The Drovers Solar Farm

Statement of Common Ground (SoCG) with Environment Agency (Clean)

Document reference: APP/5.13.2 (Revision 2)

DRAWING TITLE:
Figure 12.13: Work No. 2 Maximum Potential Foundations and Groundwater Elevations

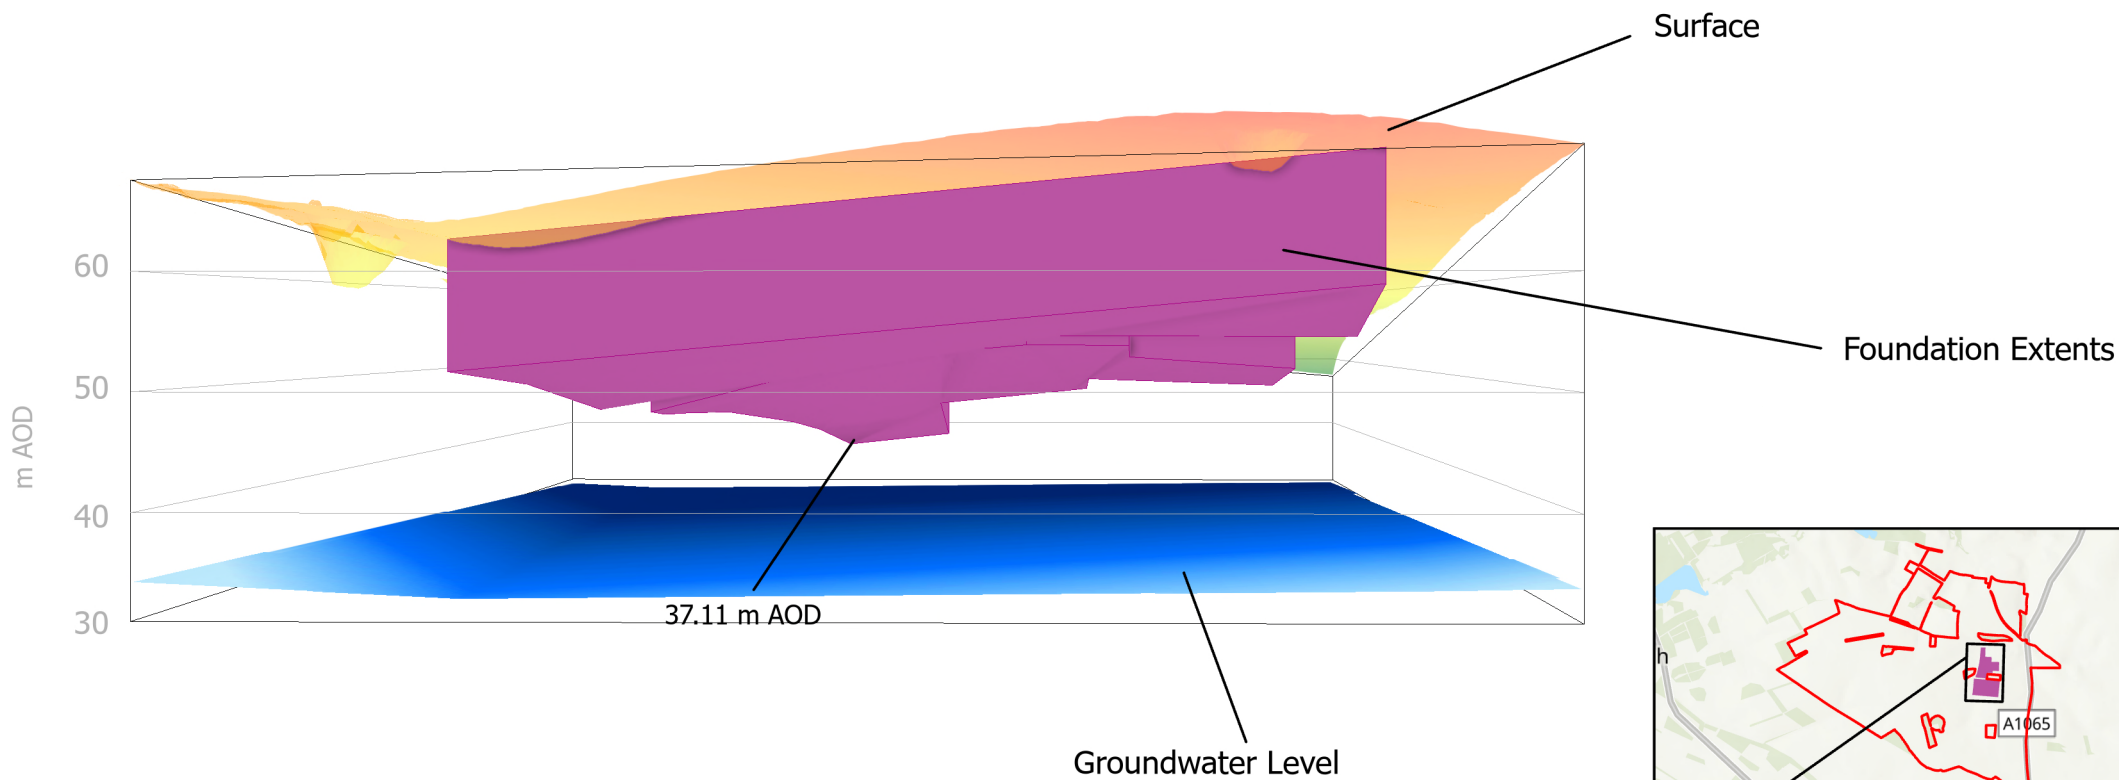
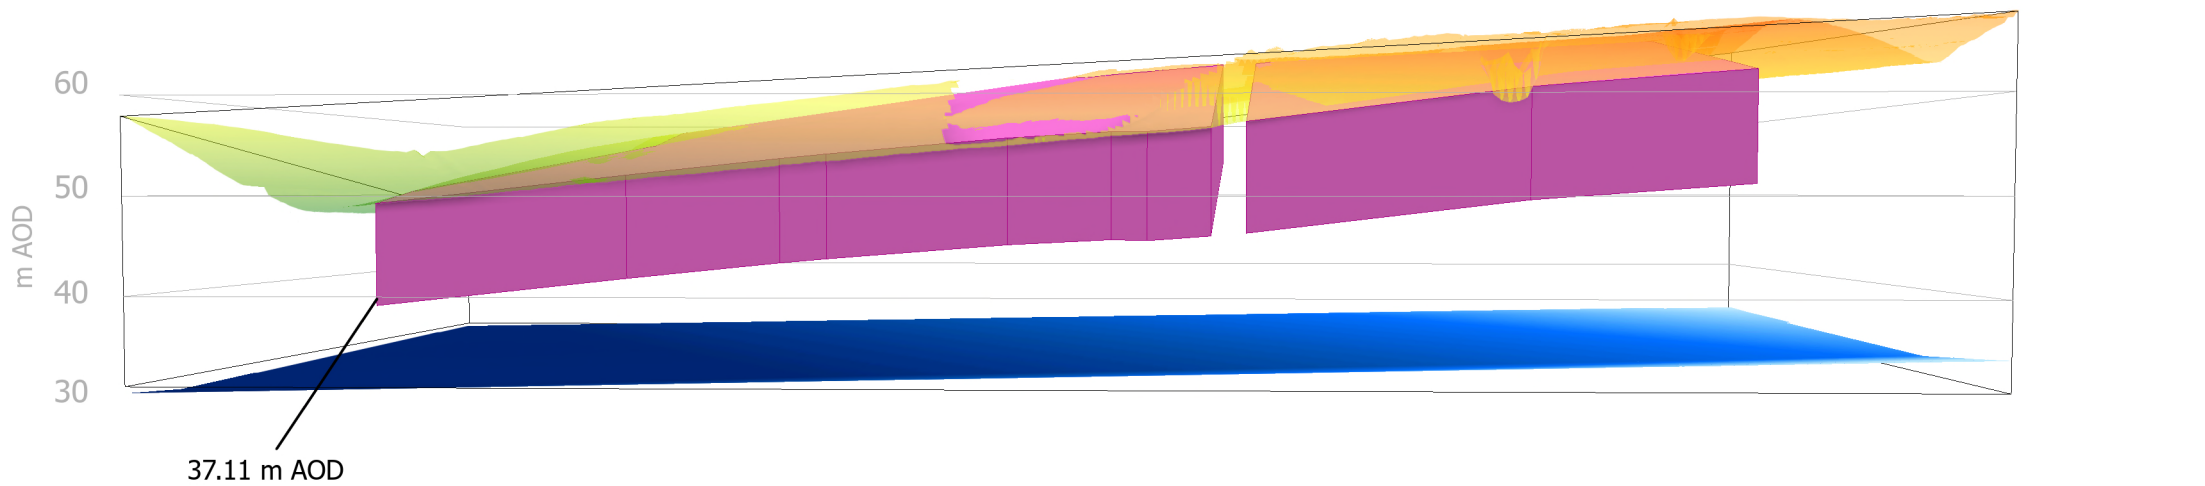
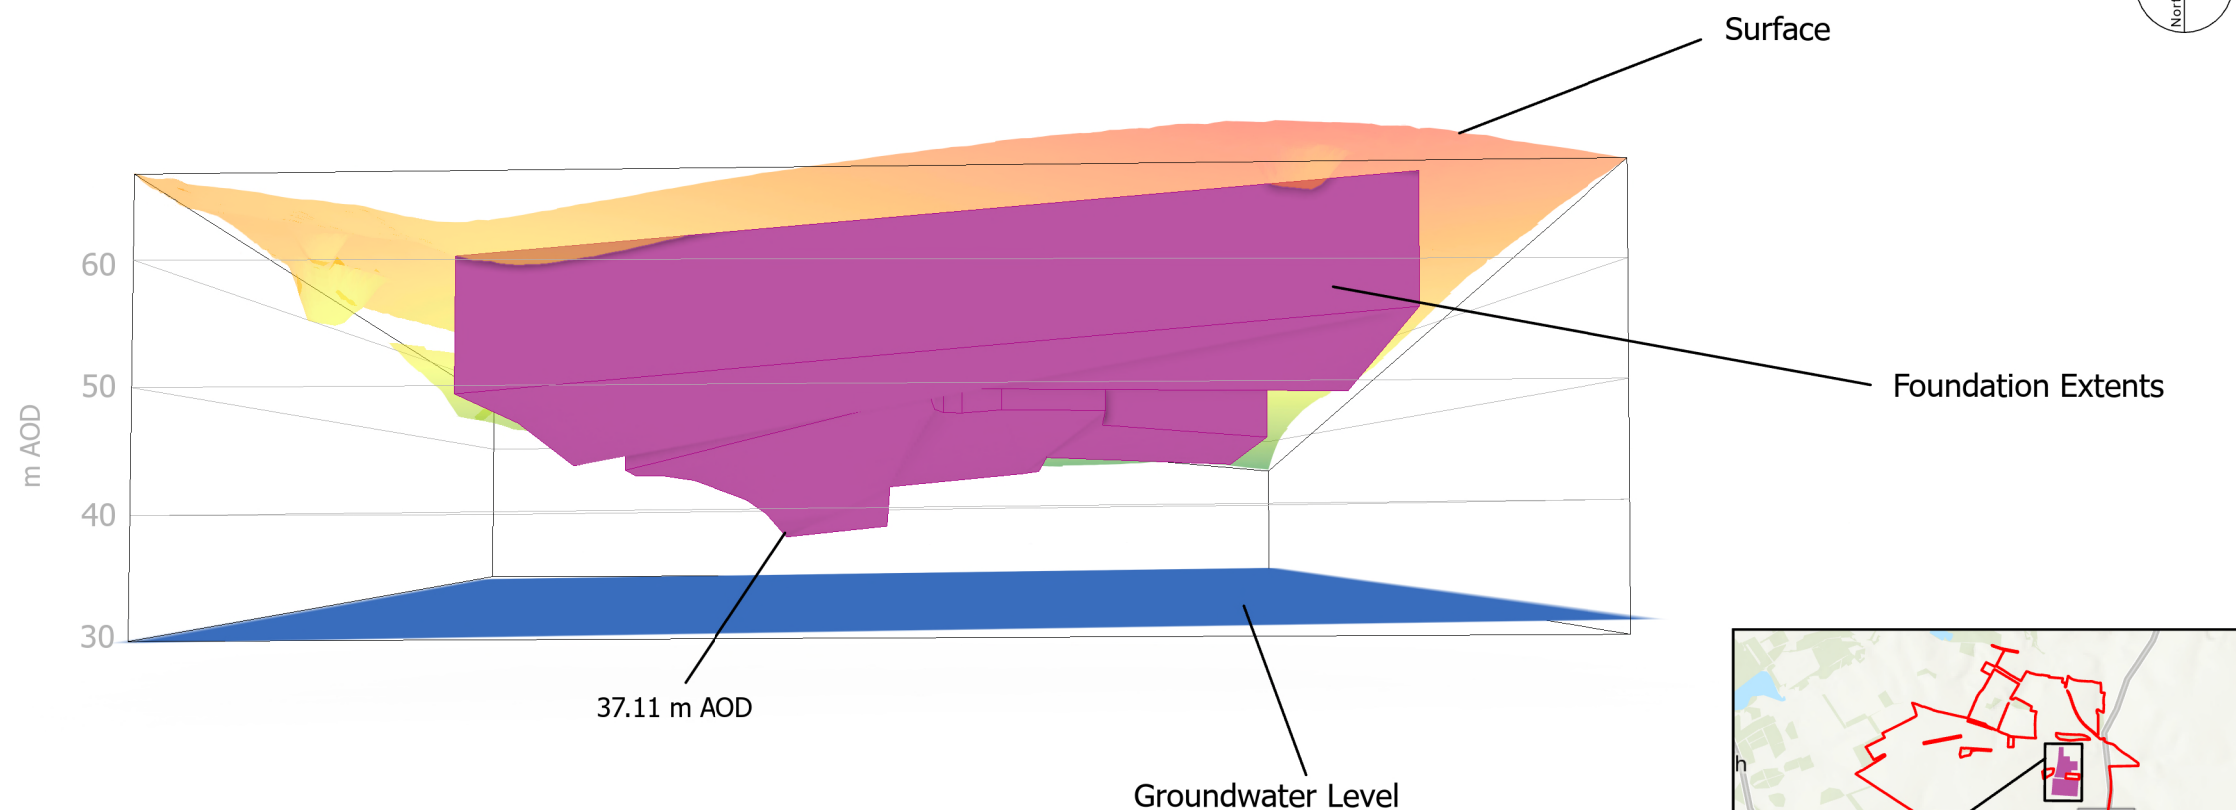
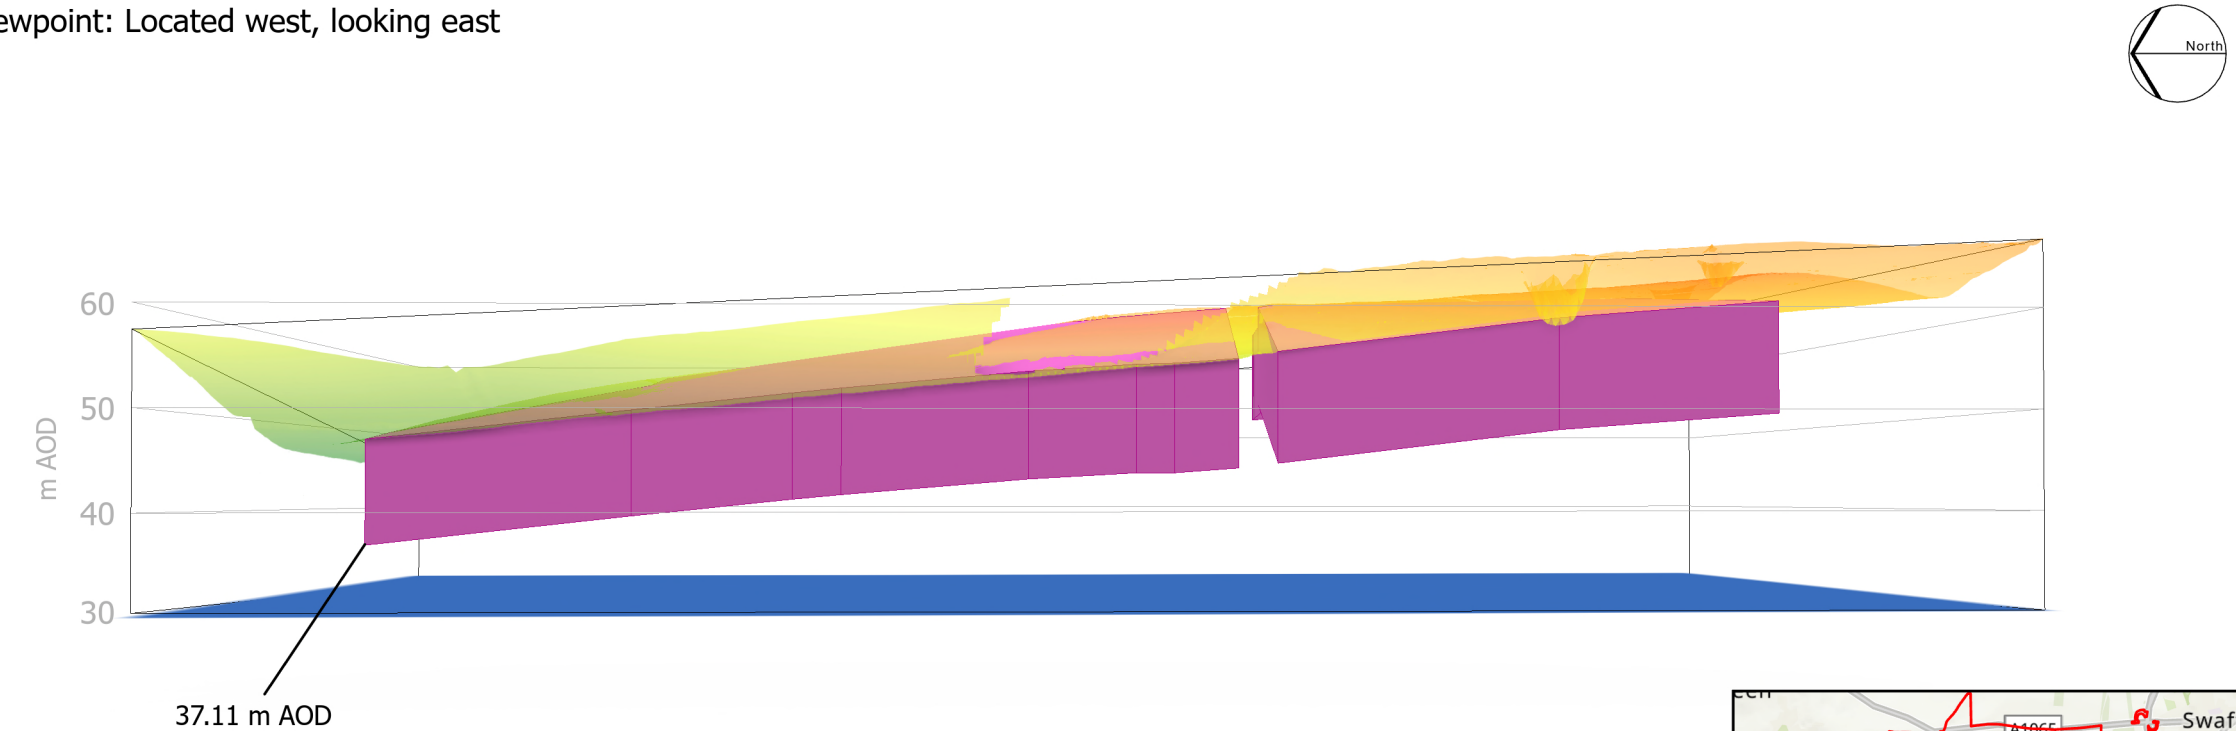
Reference	EA Issue Reference	Topic	Consultee's Position	Applicant's Position	Status
2-1	EA05	Maximum Foundation Extents	We are satisfied and consider this issue resolved. We were concerned that figures 12.13 [APP-127], 12.14 [APP-128], 12.15 [APP-129] and 12.16 [APP-130] do not clearly define the area represented by the drawings, including view orientation, or the elevation values. We have reviewed the following:	Figures 12.13 to 12.16 of ES Chapter 12: Water Resources [APP/6.2.3] were used to illustrate the maximum groundwater elevation surface across the Core Study Area and identify where proposed foundation depths could theoretically intercept shallow groundwater under worst-case conditions. The figures also demonstrate at a concept level where piling may be required depending on foundation design.	Agreed

• 6.3.1 ES Figure 12.13 Work No. 2 Maximum Potential Foundations and Groundwater Elevation [REP3-043] • 6.3.1 ES Figure 12.14 Work No. 3 Maximum Potential Foundations and Groundwater Elevation [REP3-044] • 6.3.1 ES Figure 12.15 Work No. 4 Maximum Potential Foundations and Groundwater Elevation [REP3-045] We find the updated figures satisfactory for defining the 3D model view, and elevation the maximum extent of the foundations	The following changes were made at Deadline 3 to aid the EA's interpretation: • Addition of orientation labels or description • Elevation shading to show mAOD values for the maximum groundwater elevation surface and foundation extent surface • Highlight areas where foundations intersect or exceed groundwater elevation surfaces; and • Figures and text refer to groundwater elevation (mAOD) rather than groundwater level to increase clarity between absolute elevation and depth below ground. The Applicant agrees that the conceptual model present is not the final tool for foundation design, but rather to provide a screening-level assessment of groundwater conditions and to identify areas needing piled or shallow foundations and will be aligned with EA regional groundwater understanding (NEAC model). The Design Principles, Parameters Commitments [APP/5.8.4] was updated at Deadline 2 to commit to foundations not directly interacting with groundwater. The Applicant maintains the position that a potential interaction of up to 1 m has been
